**KIRKLEES METROPOLITAN COUNCIL
INVESTMENT & REGENERATION SERVICE**

**DELEGATED DECISION TO DETERMINE APPLICATIONS FOR
NON-MATERIAL AMENDMENTS**

Reference No: 2025/NM/93455/W

Site Address: Wappy Springs Inn, Lindley Moor Road, Lindley Moor,
Huddersfield, HD3 3TD

UNITS 9 TO 15
BUILDING PLANS

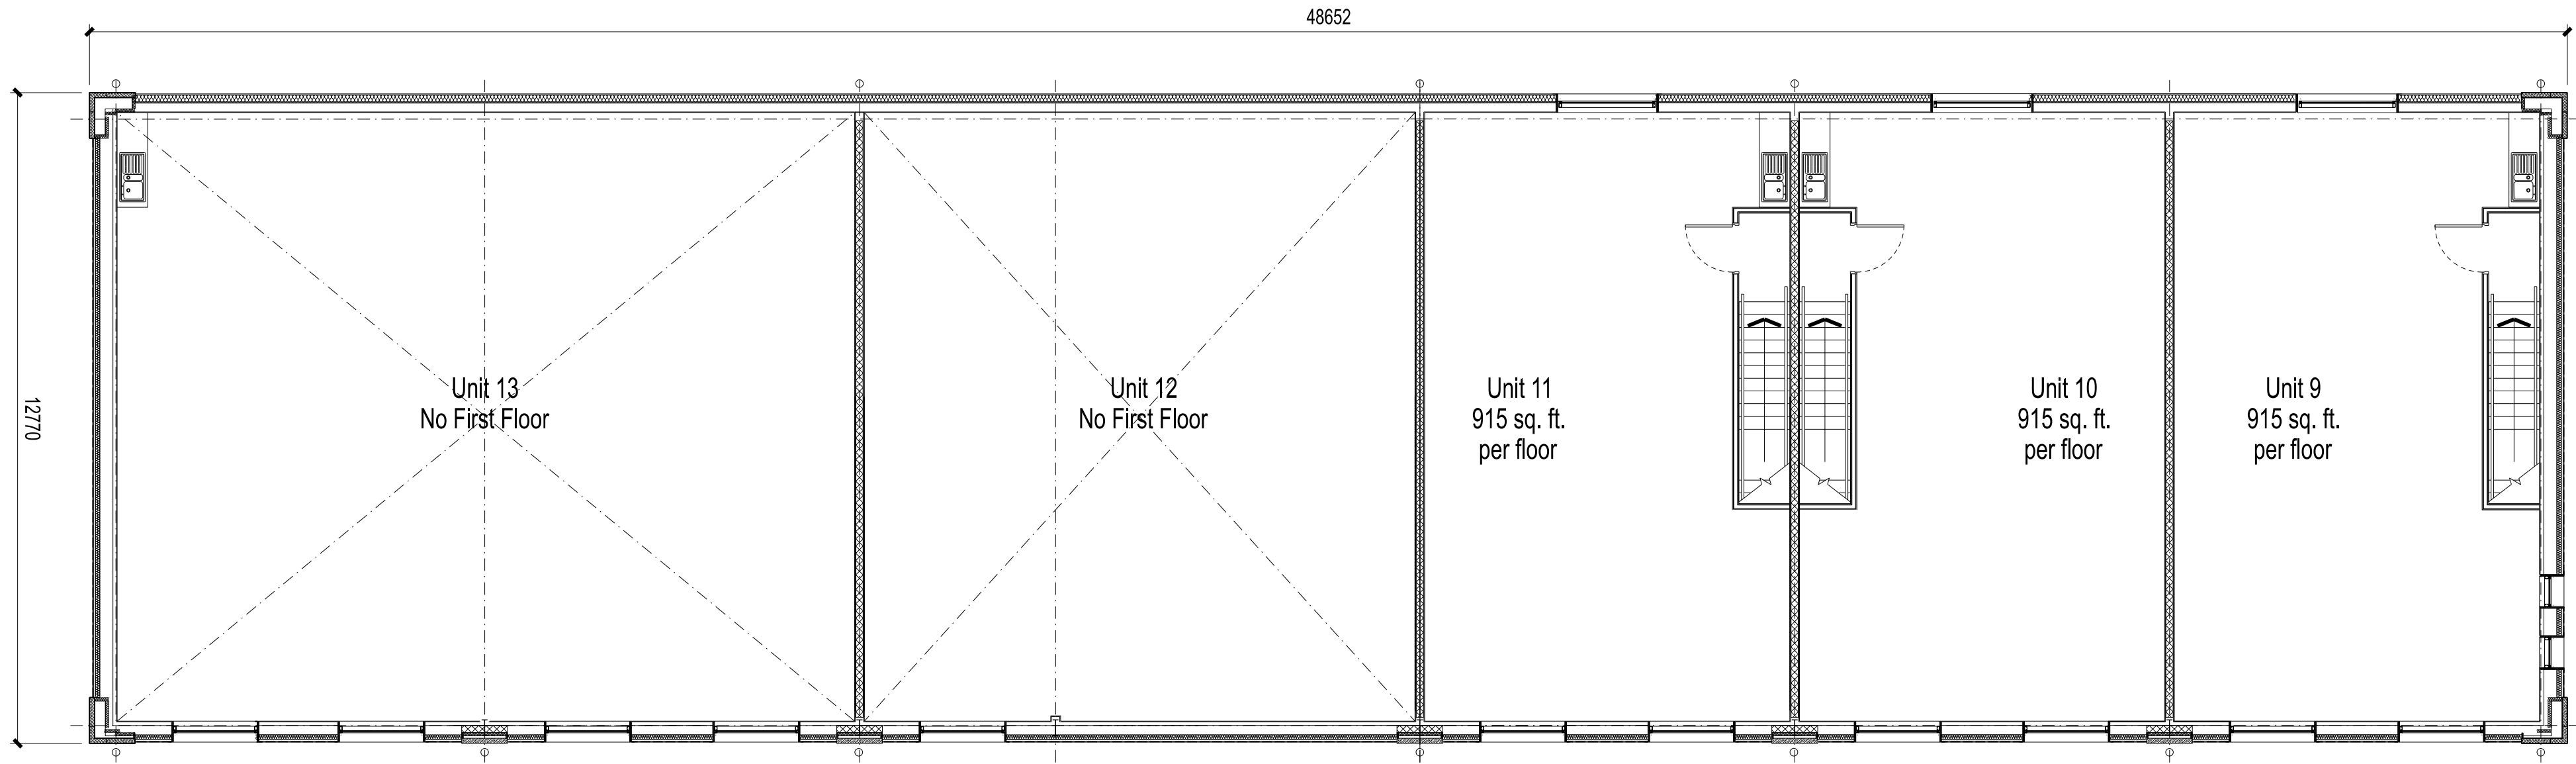
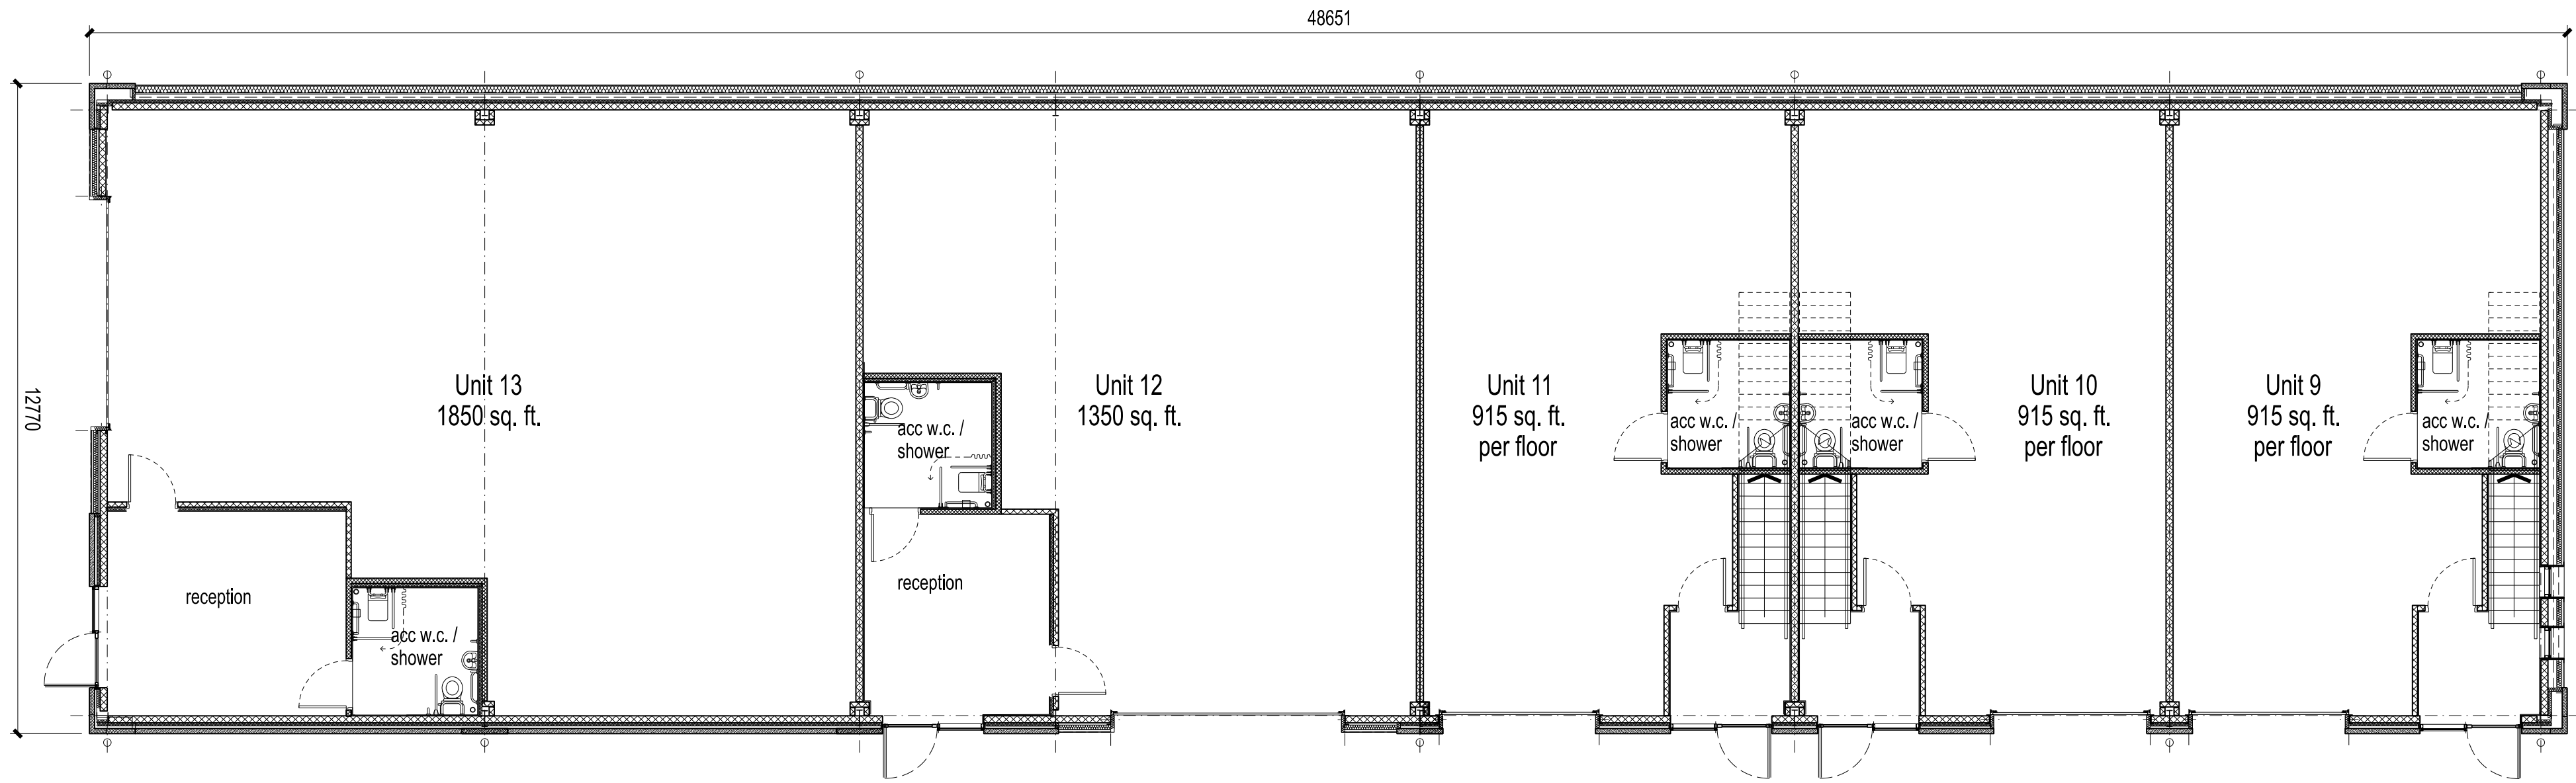
- Removal of unit 14 (previously approved at 125 sqm) and redistribute the floor space
- Redistribution of floor space to increase ground floor space of unit 12 from 85 sqm to 127 sqm
- Redistribution of floor space to increase ground floor space of unit 13 from 85 sqm to 172 sqm
- Removal of upper floor to units 12 and 13
- Reconfiguration of parking layout and external works

The amendment is for a re-configuration of the approved layout of the south-western block (units 9-14) to include the removal of unit 14, and the redistribution of the floor space via an increase in the ground floor space of units 12 and 13, as well as removal of the upper floors (ancillary office space). The reconfiguration would be inconsequential in terms of the overall scale of the approved development, with a net zero floor space change for the overall development.

UNITS 9 - 15 ELEVATIONS

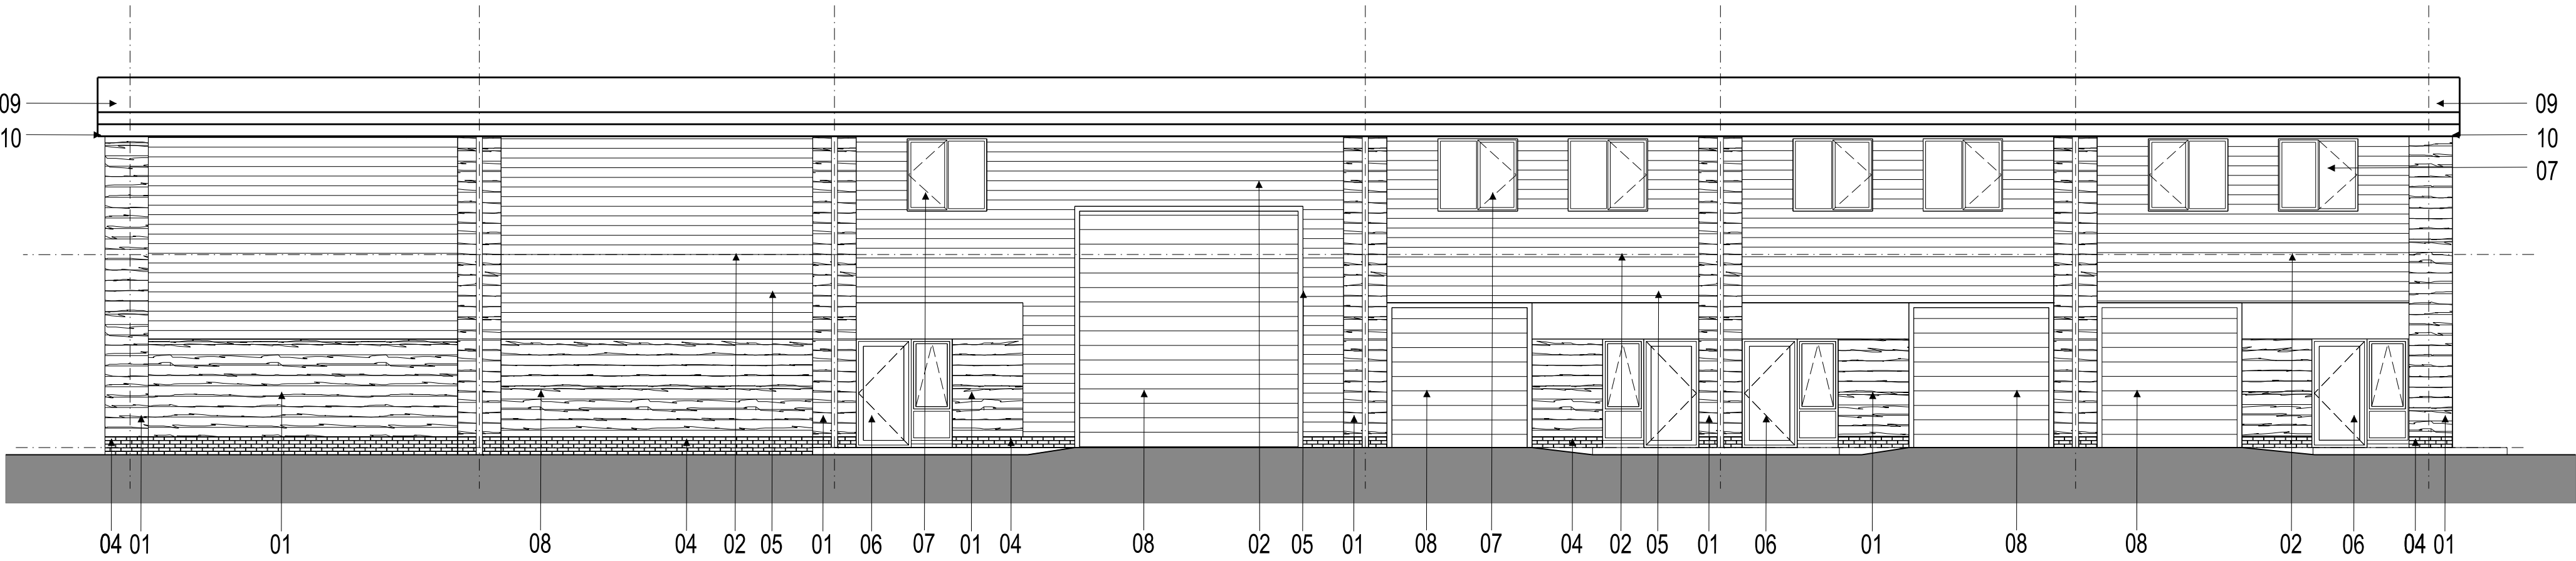
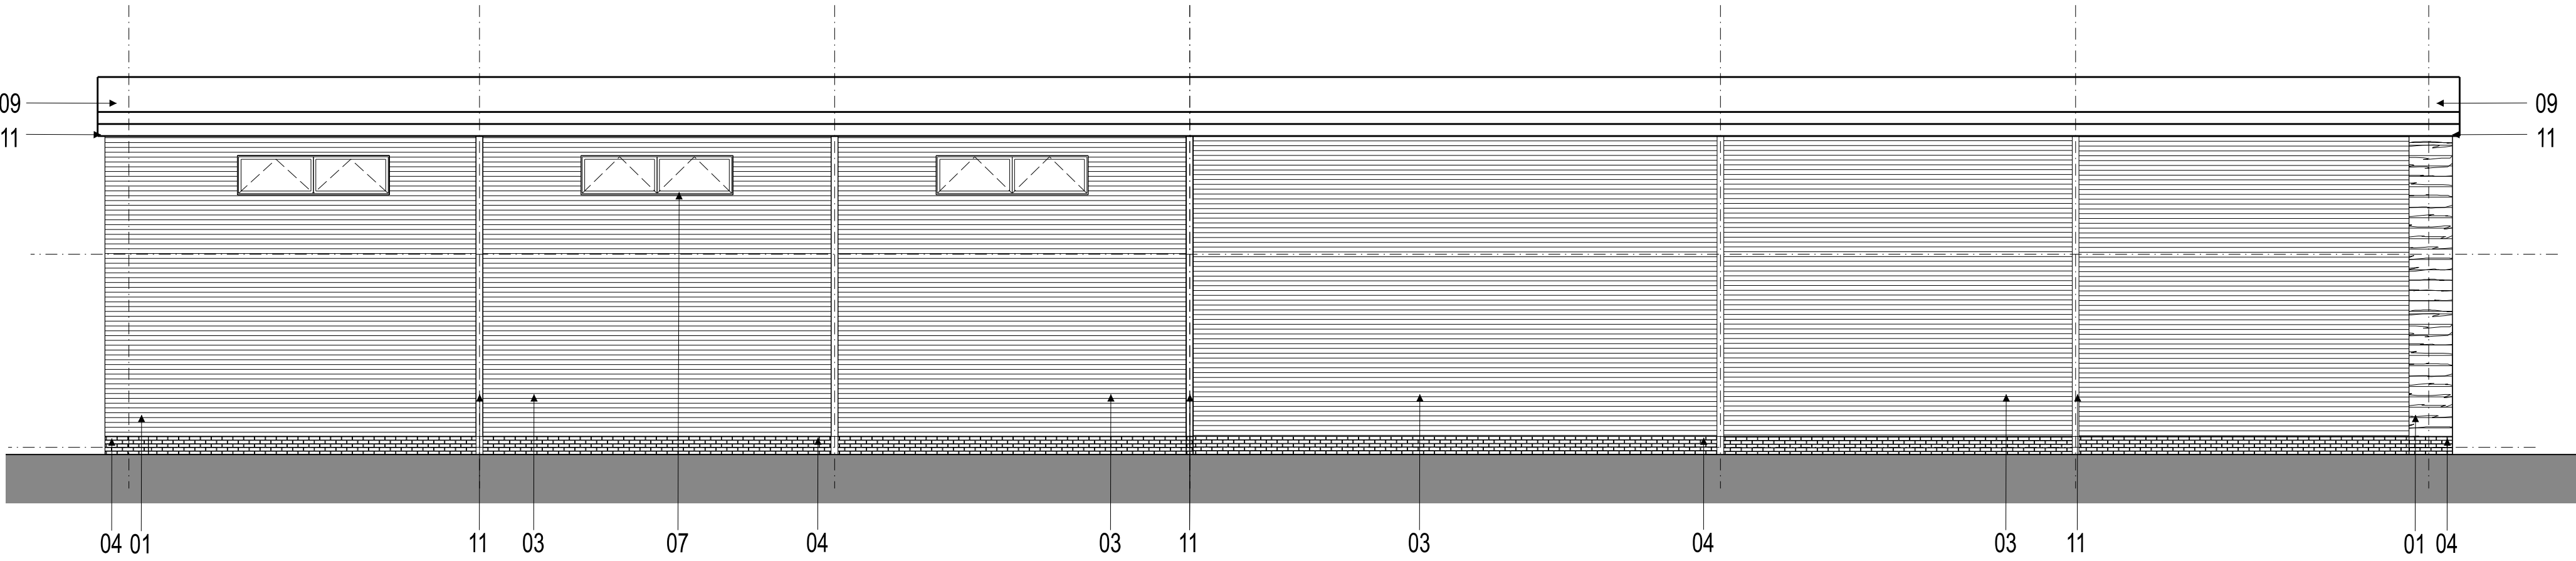
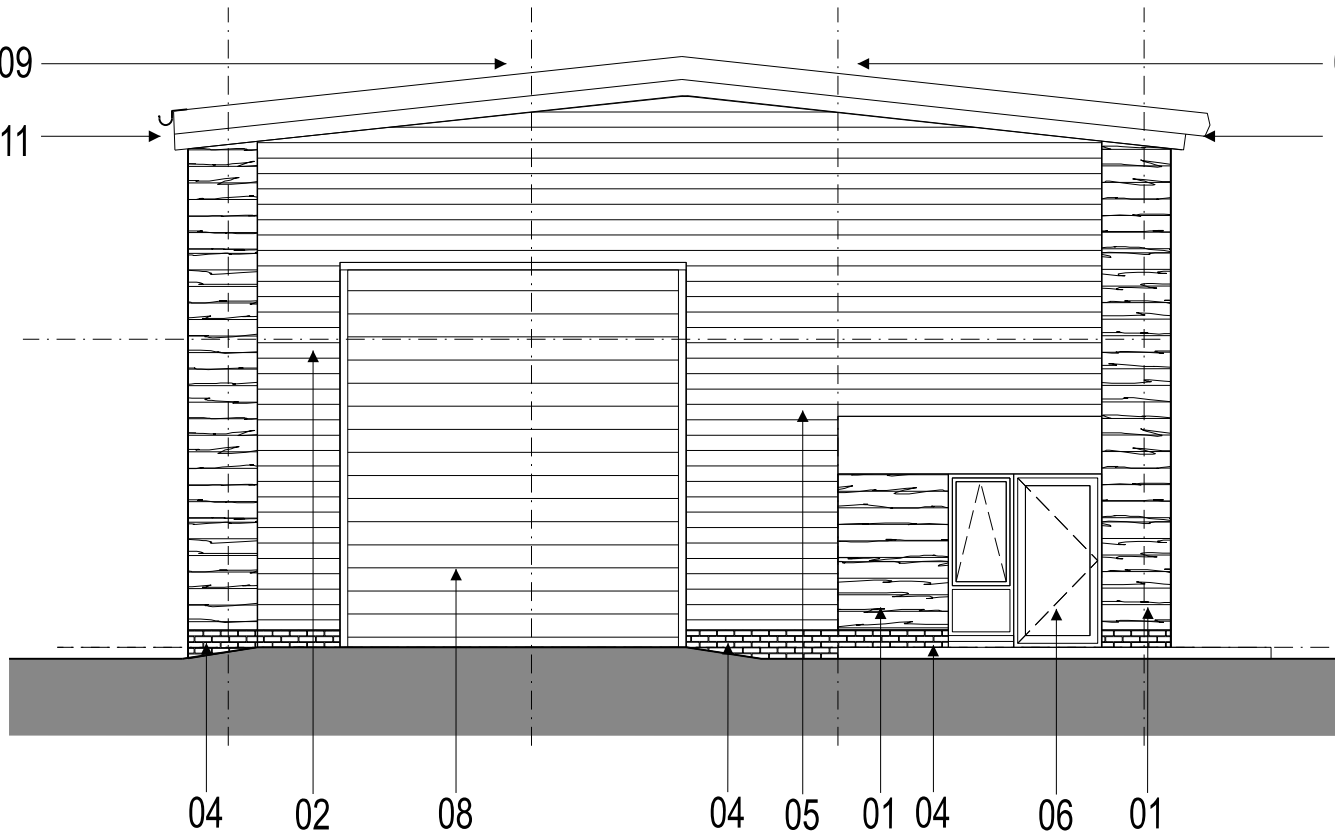
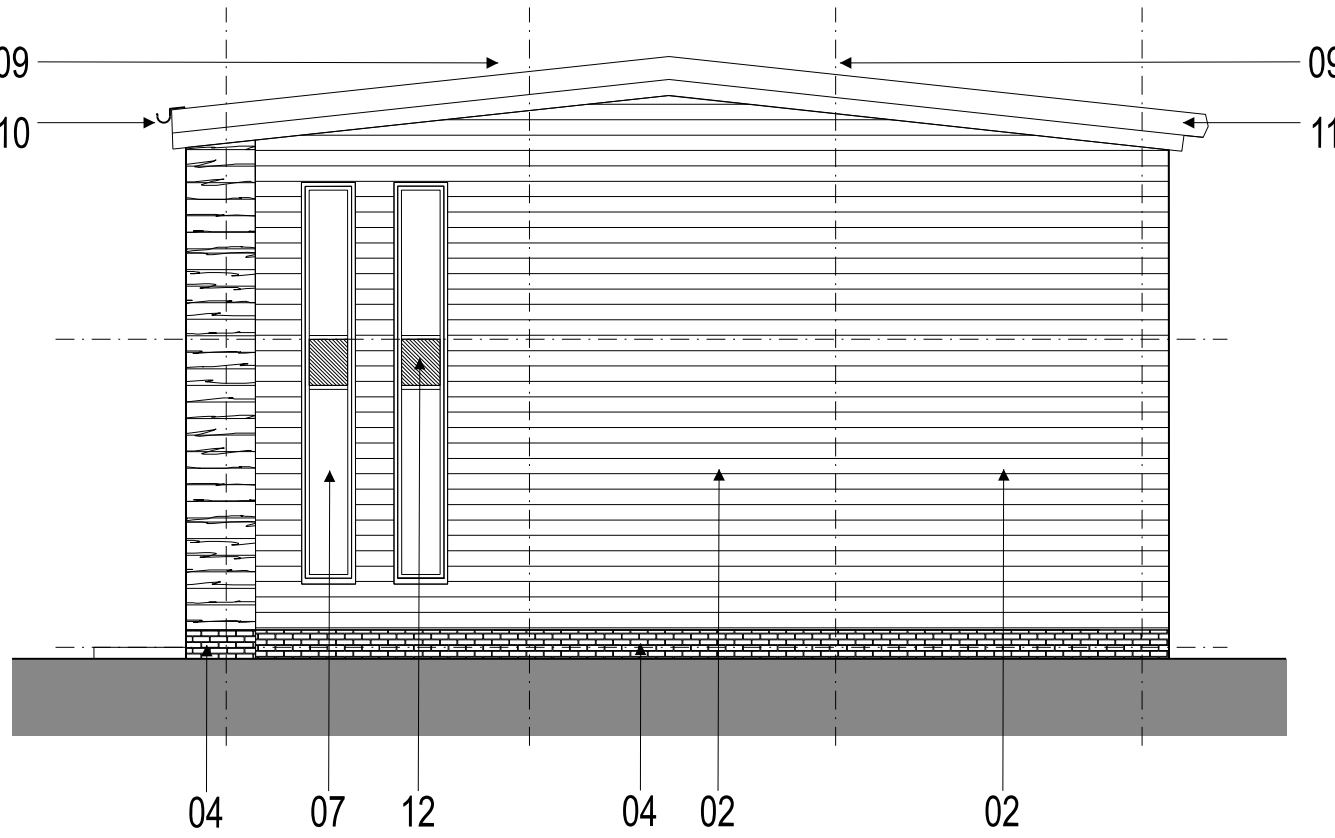
- Removal of window openings to the front elevation
- Addition of overhead door to the front elevation to serve reconfigured unit 12
- Repositioning of door opening and windows and addition of overhead door opening to side elevation to serve reconfigured unit 13

The proposed amendments to the fenestration detailing include the removal of window openings to the front elevation, the addition of an overhead door to serve the reconfigured unit 12, the repositioning of door opening and windows, and the addition of an overhead door opening to the side elevation to serve unit 13. It is considered these amendments would not have a detrimental impact on the appearance of the building as approved, or the visual amenity of the site and its surroundings.
